EL PASO COUNTY GRADING AND EROSION CONTROL PLAN CHECKLIST

Please add PCD File
PPR-22-017

SHEET
C1.1

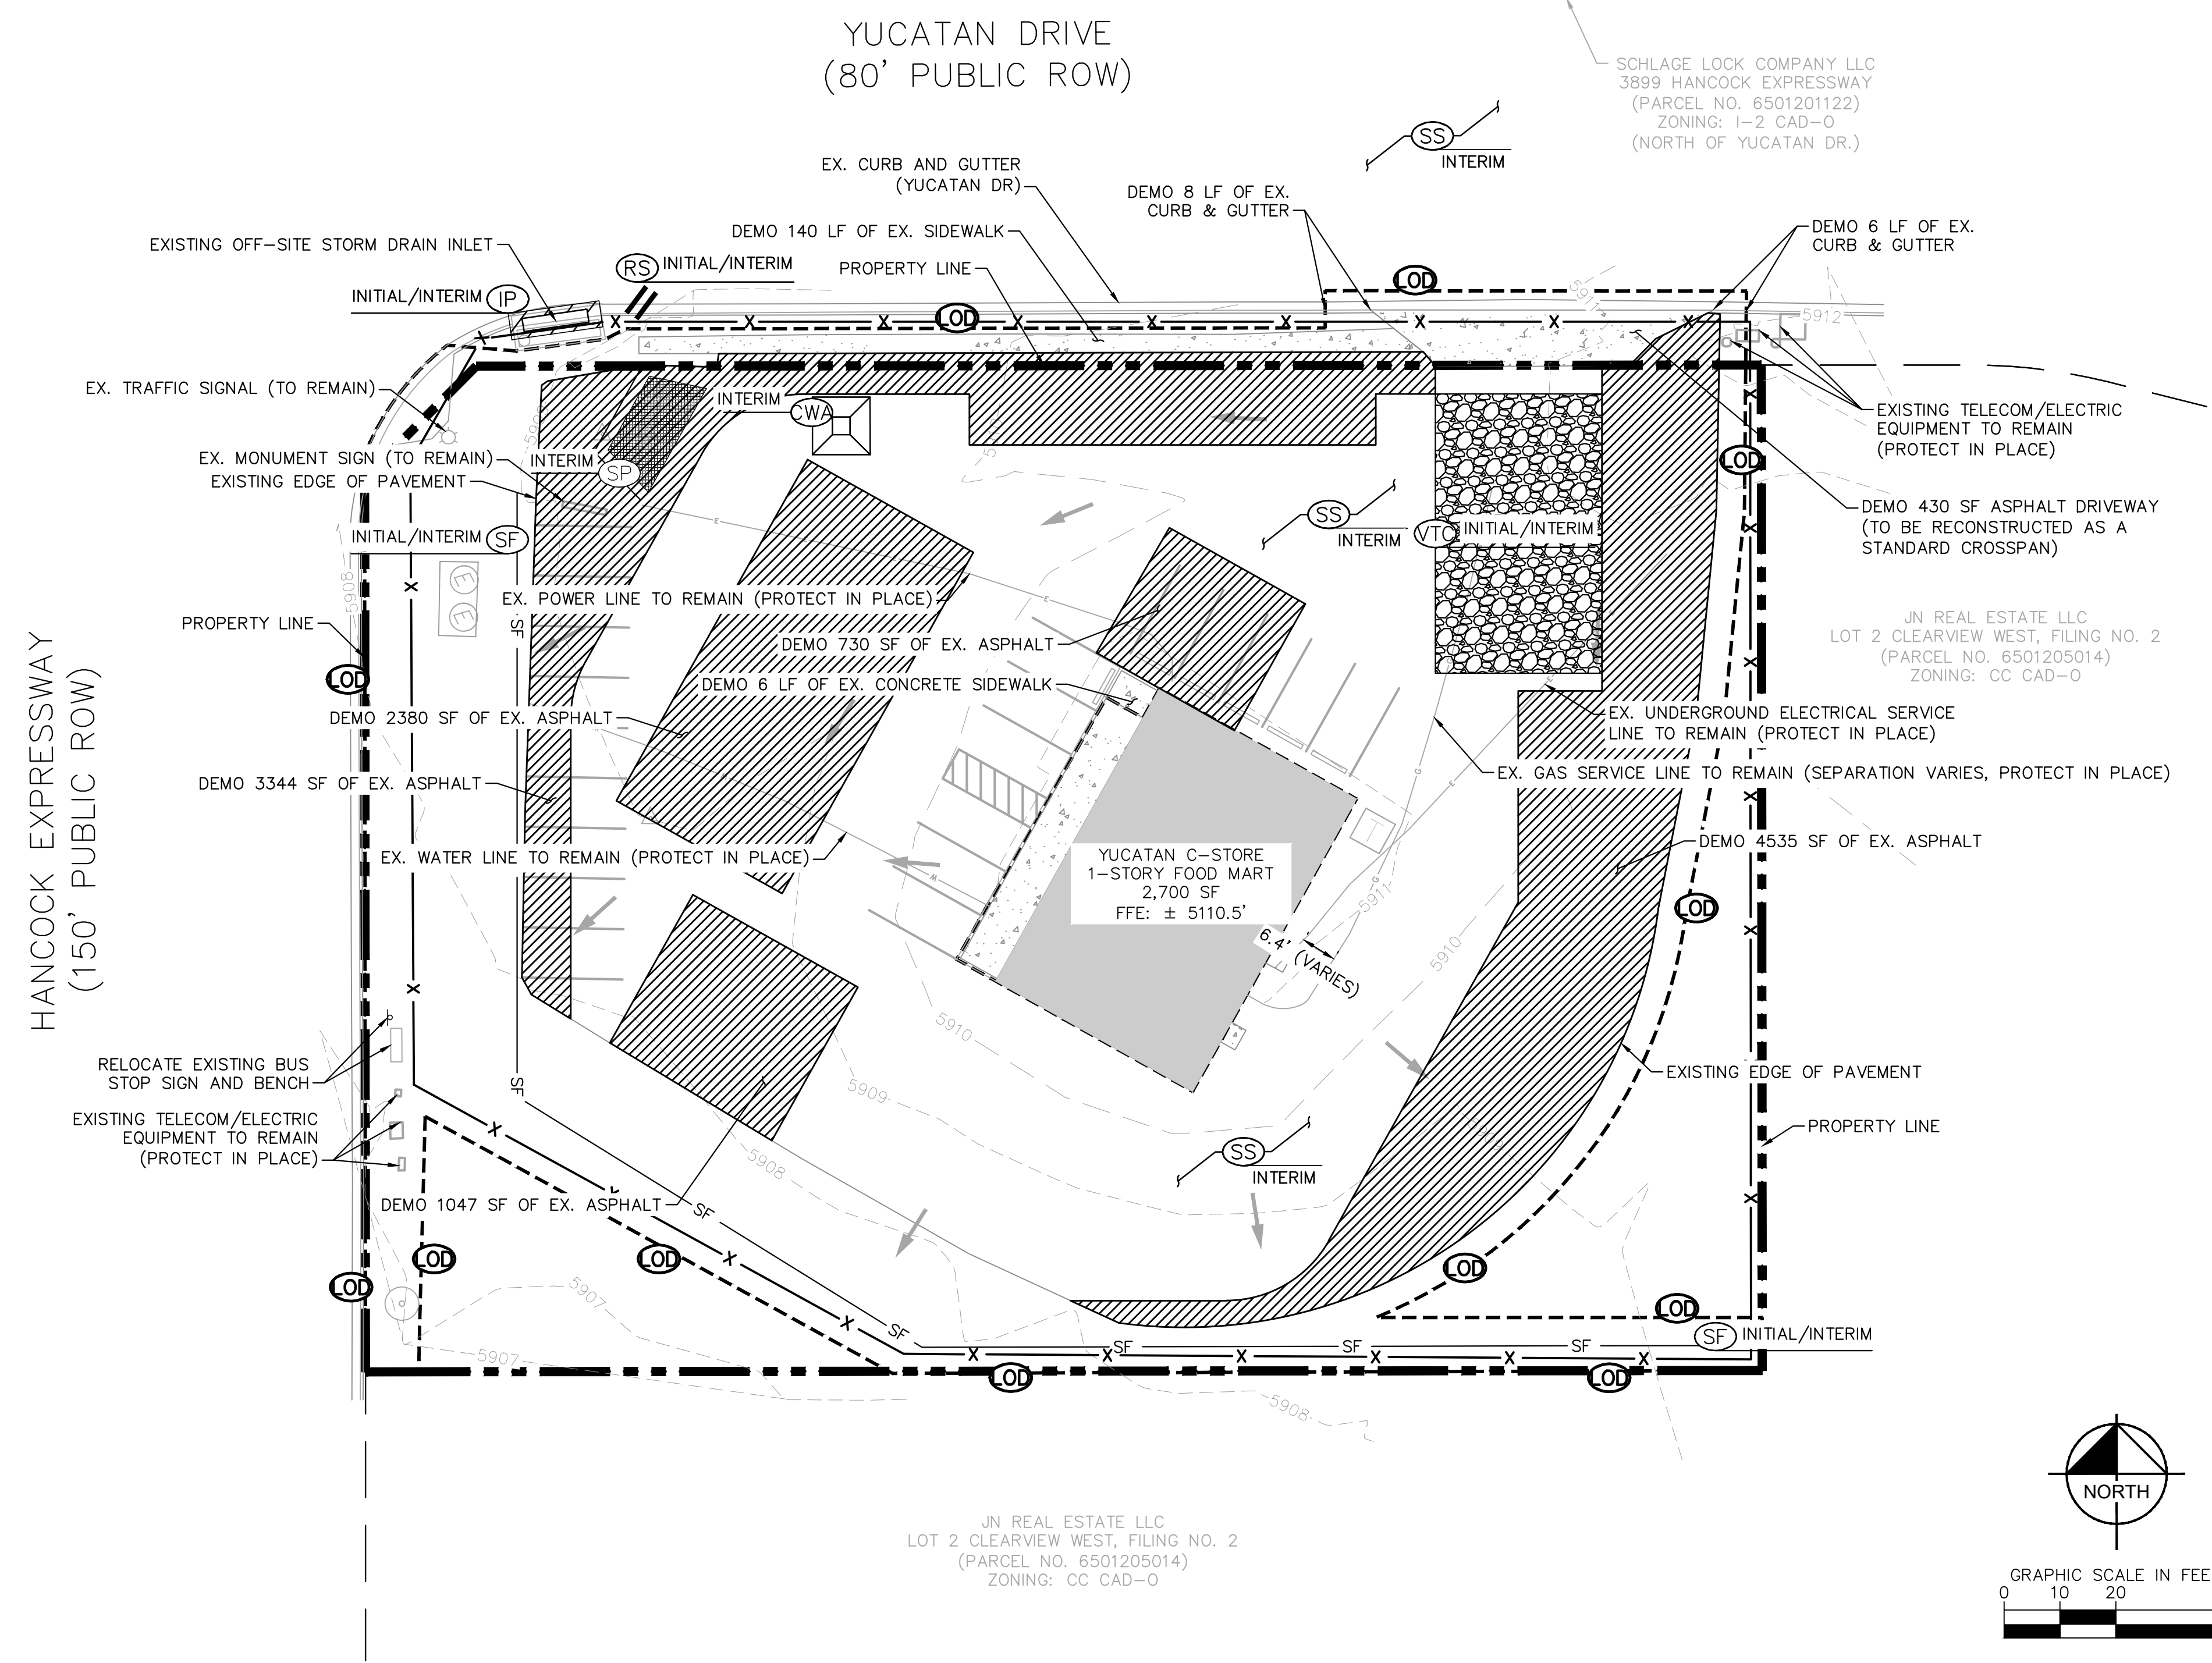
l	Existing and proposed contours 2 feet or less (except for hillside)		✓
m	Limits of disturbance delineating all anticipated areas of soil disturbance		✗
n	Identify and protect areas outside of the construction site boundary with existing fencing, construction fencing or other methods as appropriate see comment on GEC about CF		✗
o	Off-site grading clearly shown and called out (No offsite grading associated with this project)		N/A
p	Areas of cut and fill identified see comment on GEC about cut/fill delineation		✗
q	Conclusions from soils/geotechnical report and geologic hazards report incorporated in grading design (slopes, embankments, materials, mitigation, etc.) (Limited grading design)		✓
r	Proposed slopes steeper than 3:1 with top and toe of slope delineated. Erosion control blanketing or other protective covering required (No steep slopes included as a part of this project)		N/A
s	Stormwater flow direction arrows		✓

Limits of disturbance delineating all anticipated areas of soil disturbance

Identify and protect areas outside of the construction site boundary with existing fencing, construction fencing or other methods as appropriate

Areas of cut and fill identified

Construction site boundaries

see comment on GEC about CF

see comment on GEC about cut/fill delineation
